November 29, 2024

**Re: Response to Technical Comments – SPC Application D07-12-24-0087; 2900 Brian Coburn Blvd./119 Ryan Reynolds Way**

DRAWING #: **L.2** REV #:

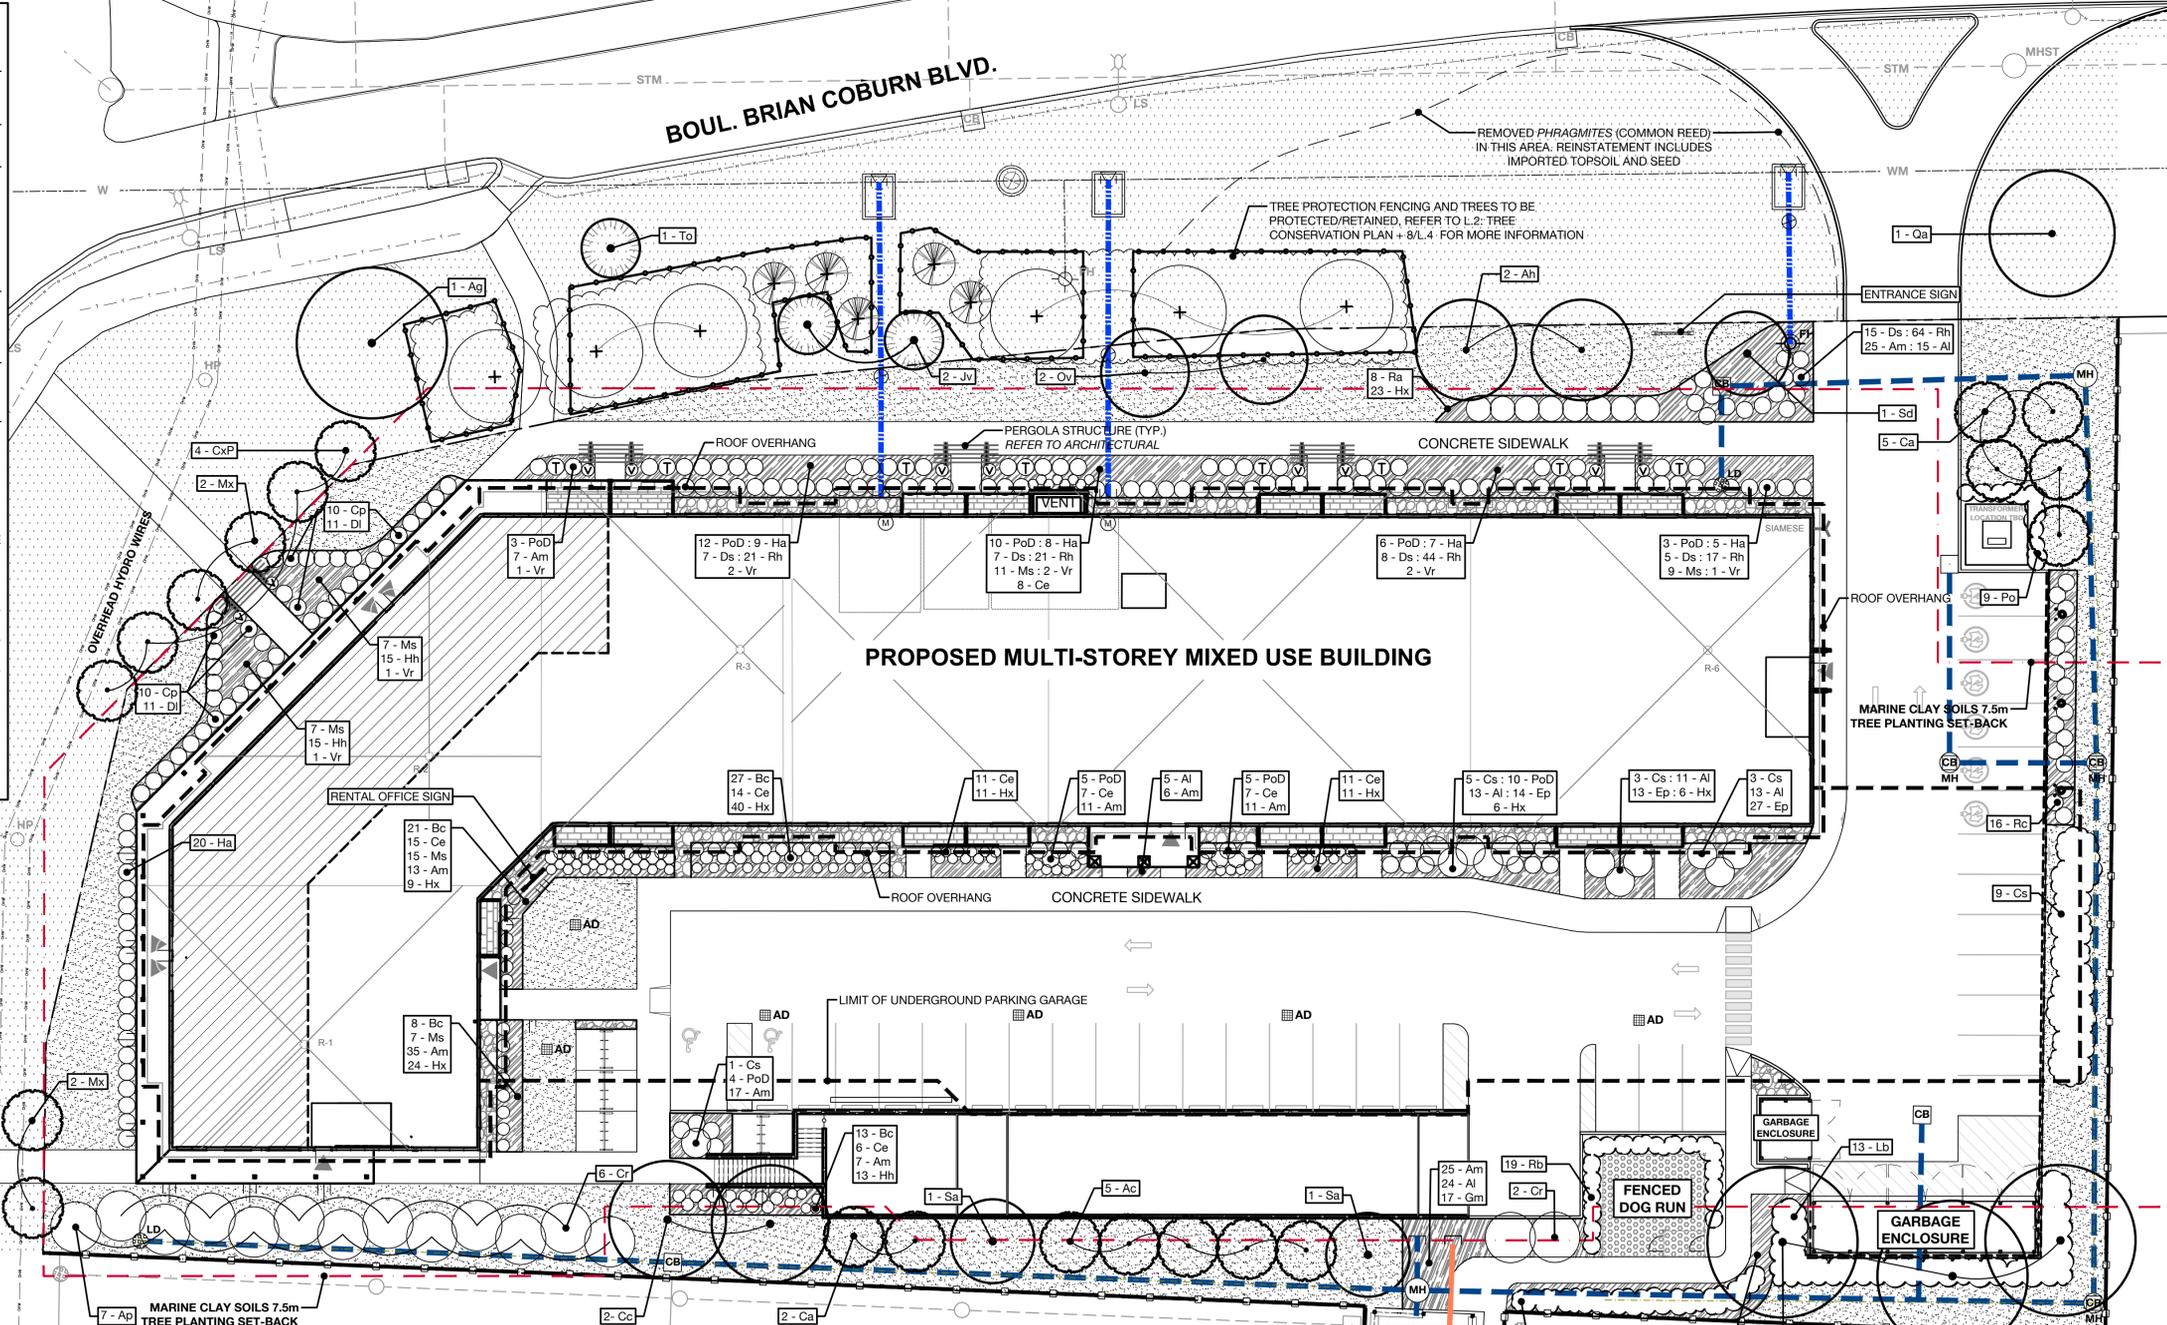
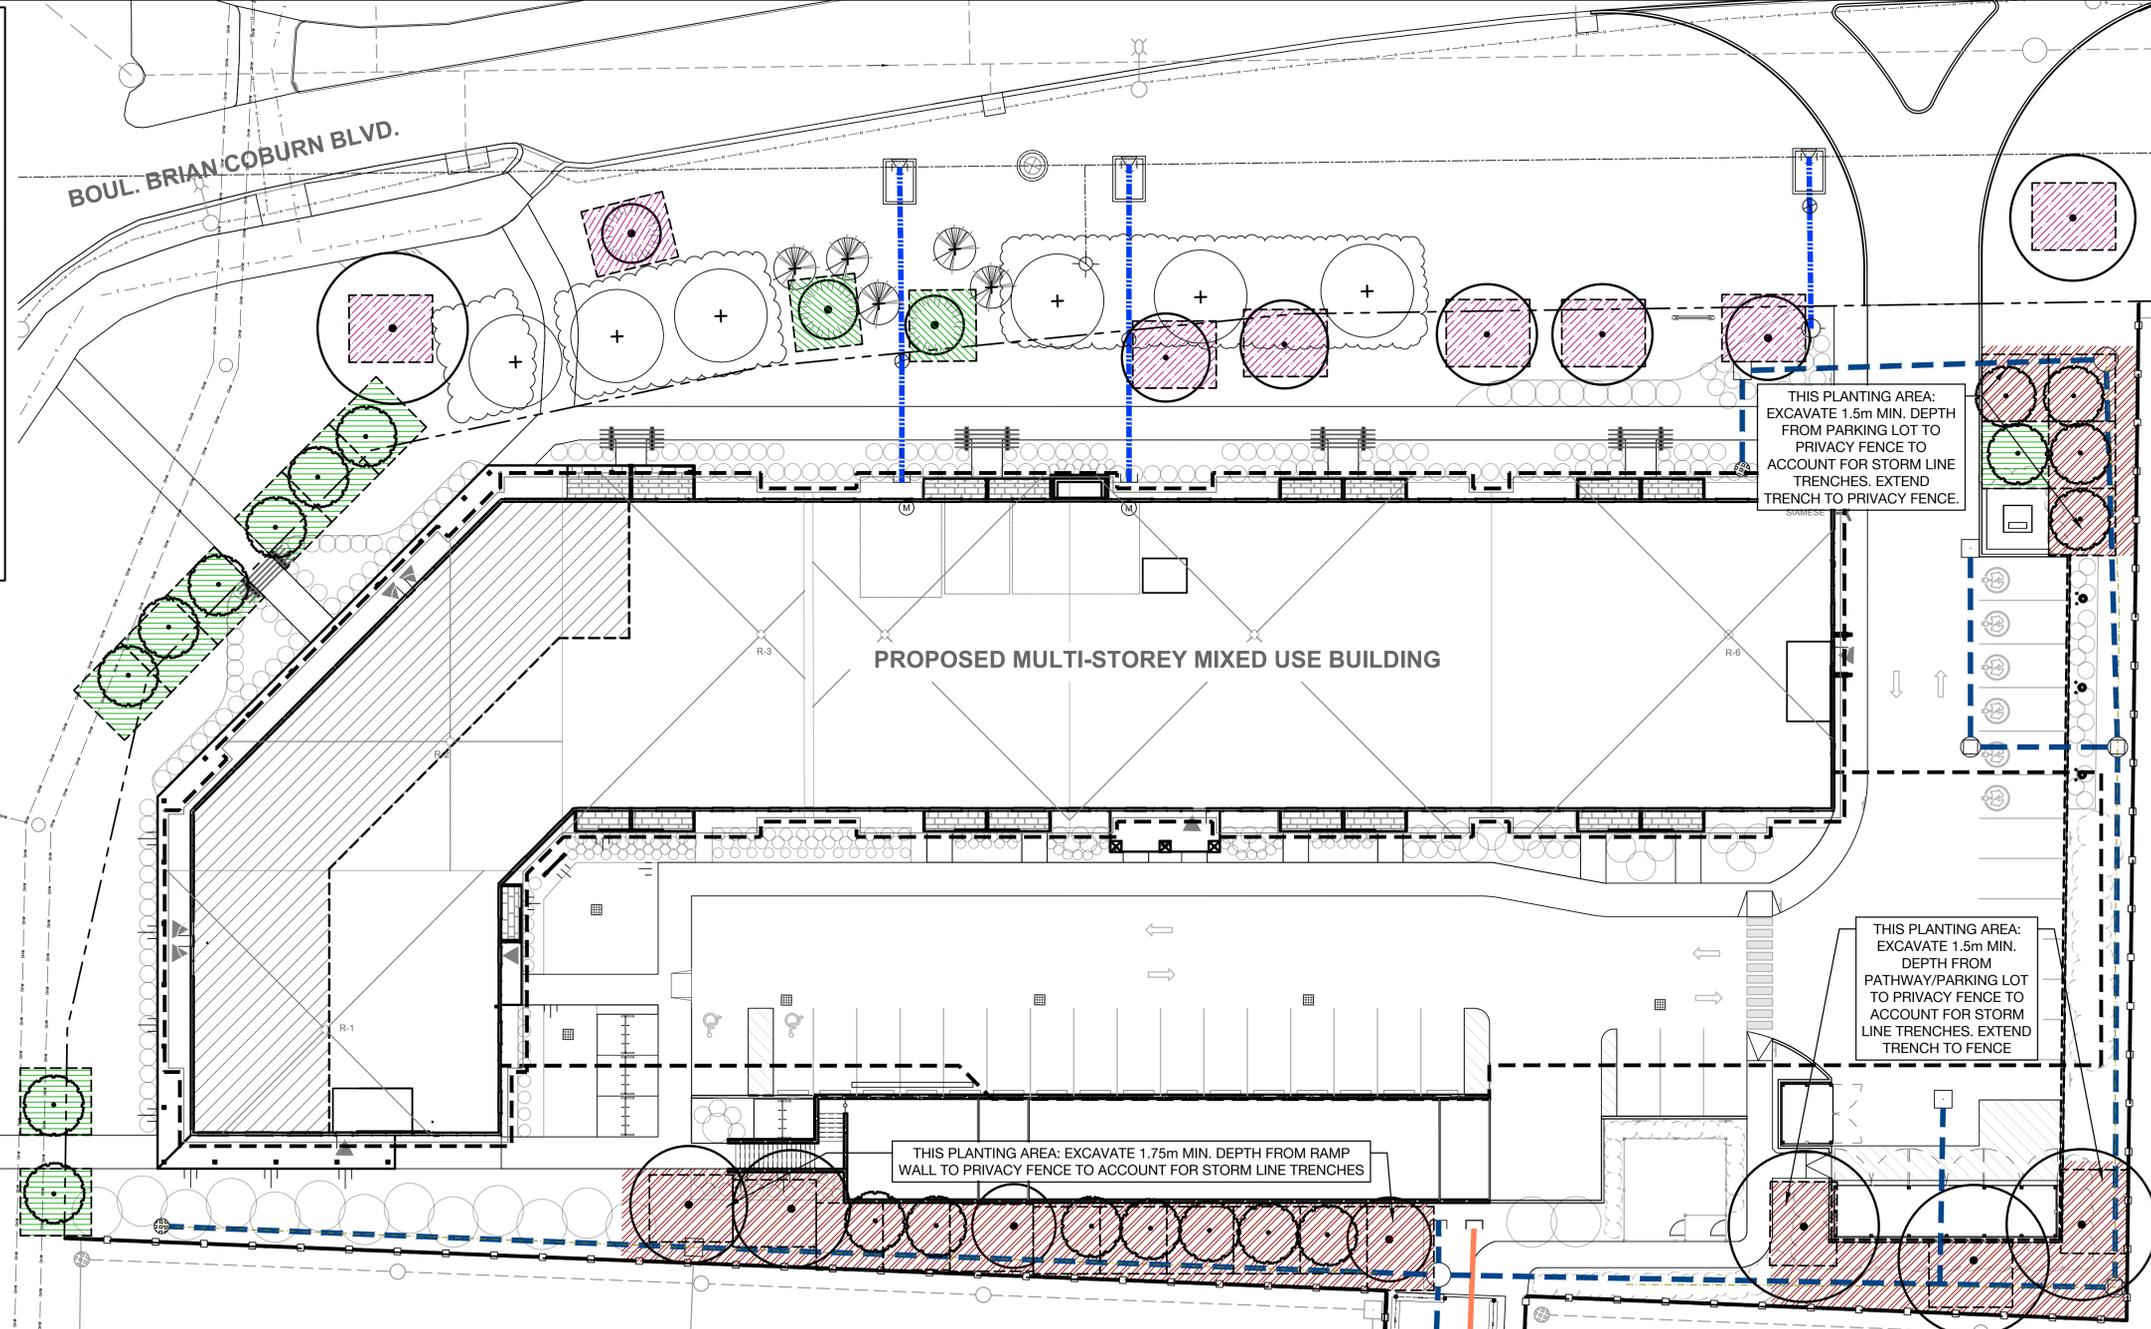
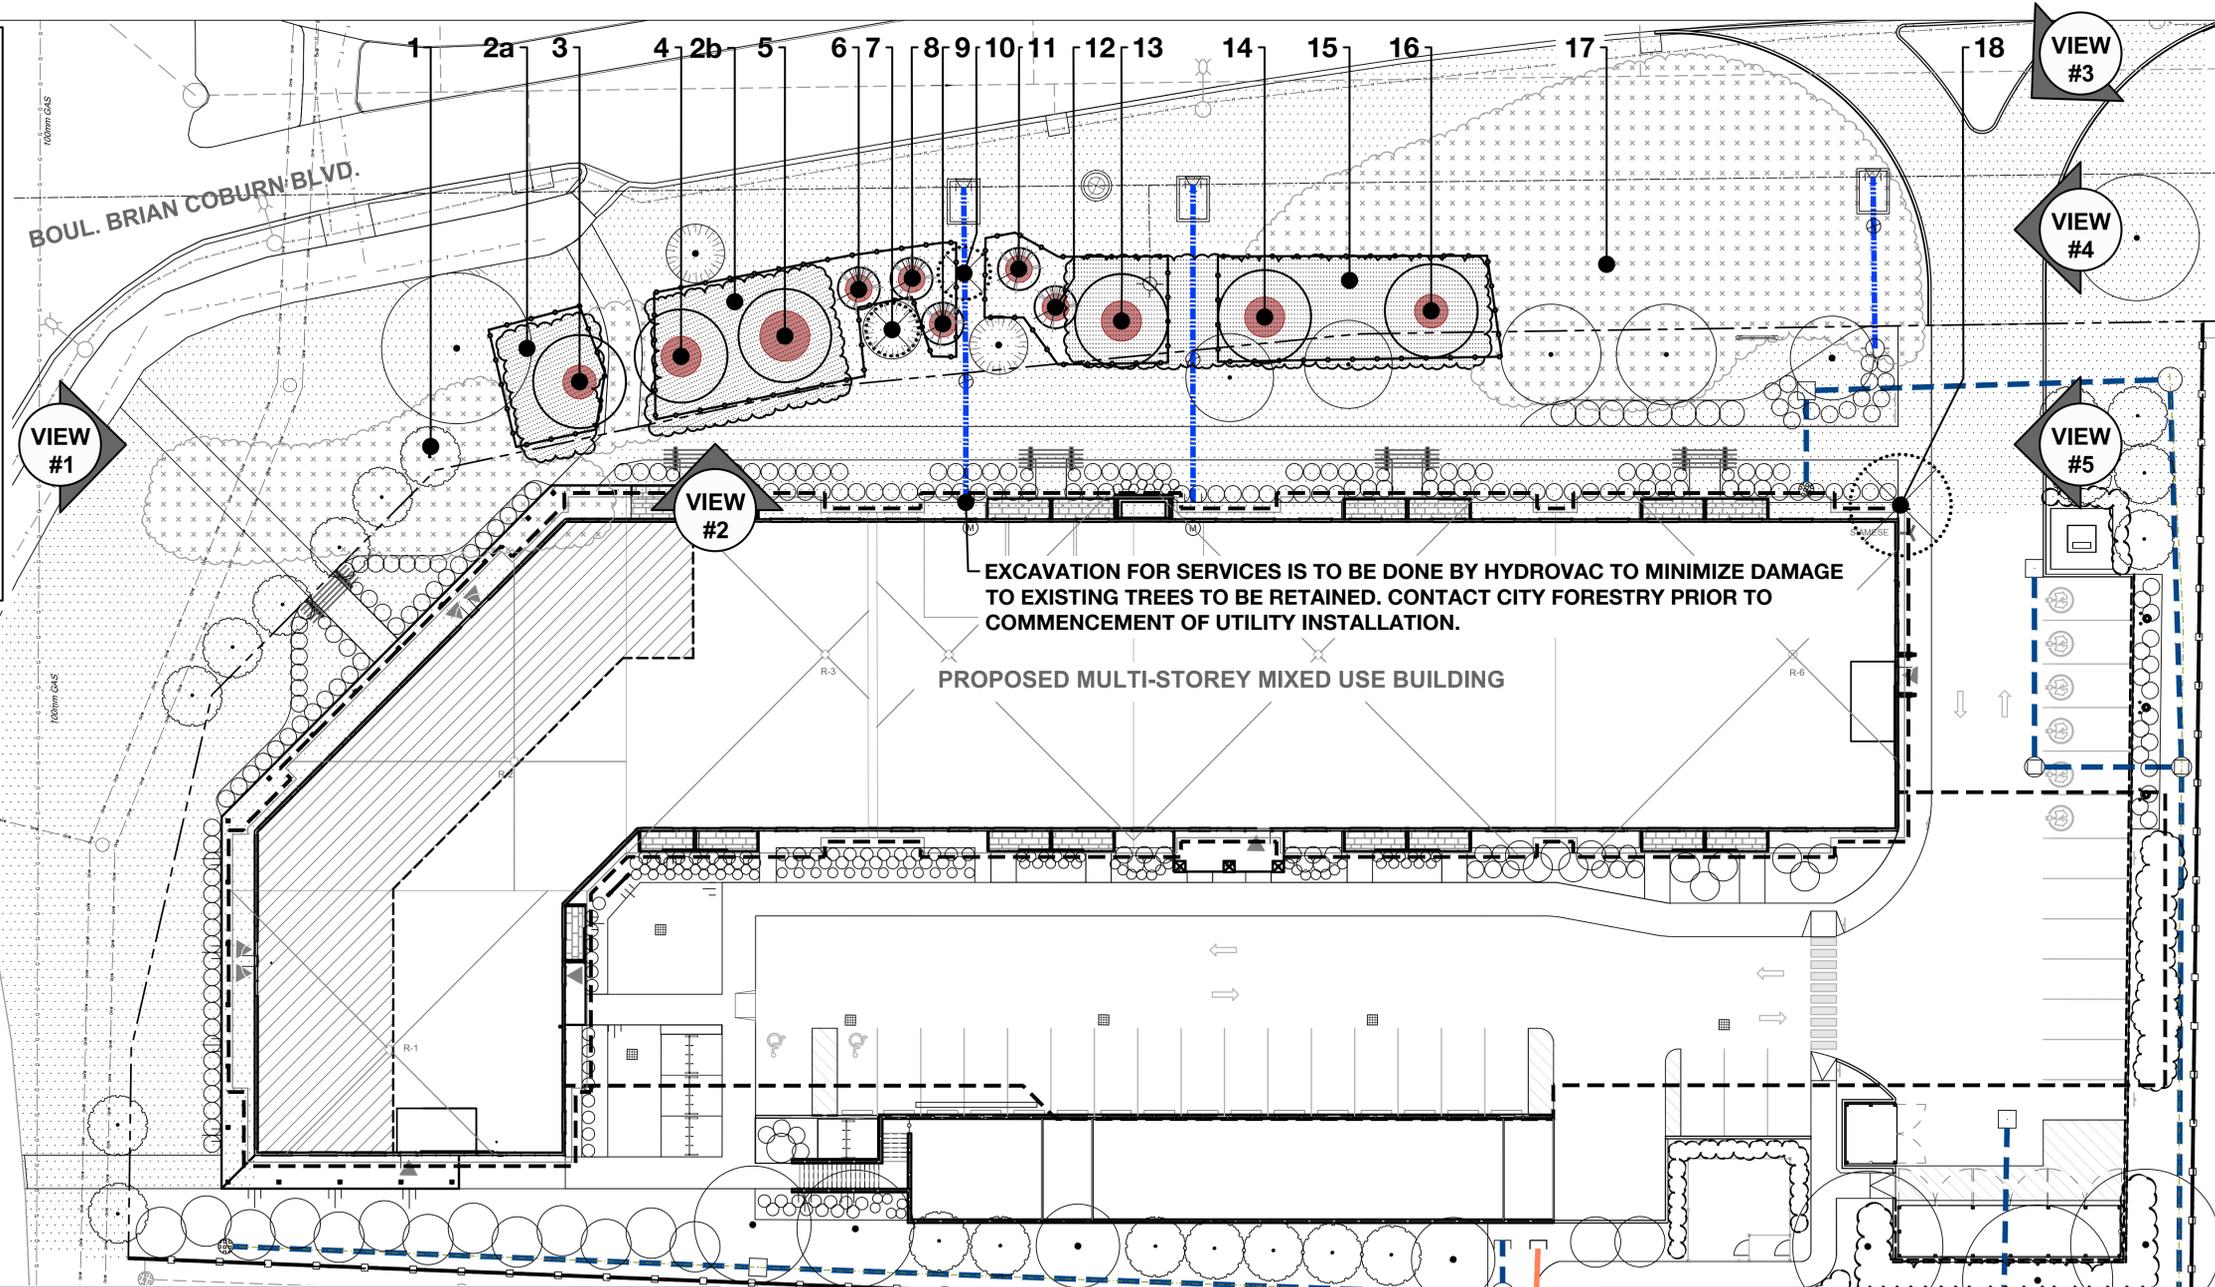
6. Tree # 10 is City owned. Removal would require justification. If justified, a permit and replacement planting is required. A white spruce would need to be planted as compensation. Please explain why the location of the watermain can not be moved? For	Please see revised Civil drawings and updated landscaping plan for the relocated watermain lines.

<p>example, placed under the walkway that connects pedestrians from Brian Coburn to the north west end of the building. Photo included for reference:</p> 	
<p>7. Tree 9 is also in close proximity to the watermain. Show the extent of excavation needed to install the watermain to confirm it does not conflict with the CRZ of this tree. Label the excavation distance from the watermain to the furthest extent of excavation.</p>	<p>Please see revised Landscaping plan. No ROW trees will be removed.</p>
<p>8. Please use an air spade instead of a hydrovac to excavate around retained City trees.</p>	<p>The plans have been revised. No excavation will be required.</p>
<p>9. There is a note on the Soil Volume Plan saying excavate 1.75m min. Depth from ramp wall to privacy fence to account for storm line trenches. At what depth are the storm line trenches? Has the engineering consultant confirmed there is no conflict with the proximity of these trees to the proposed storm pipe? Photo included for reference:</p> 	<p>There is no longer conflict with storm and trees as trees have been removed and replaced with native shrubs.</p>
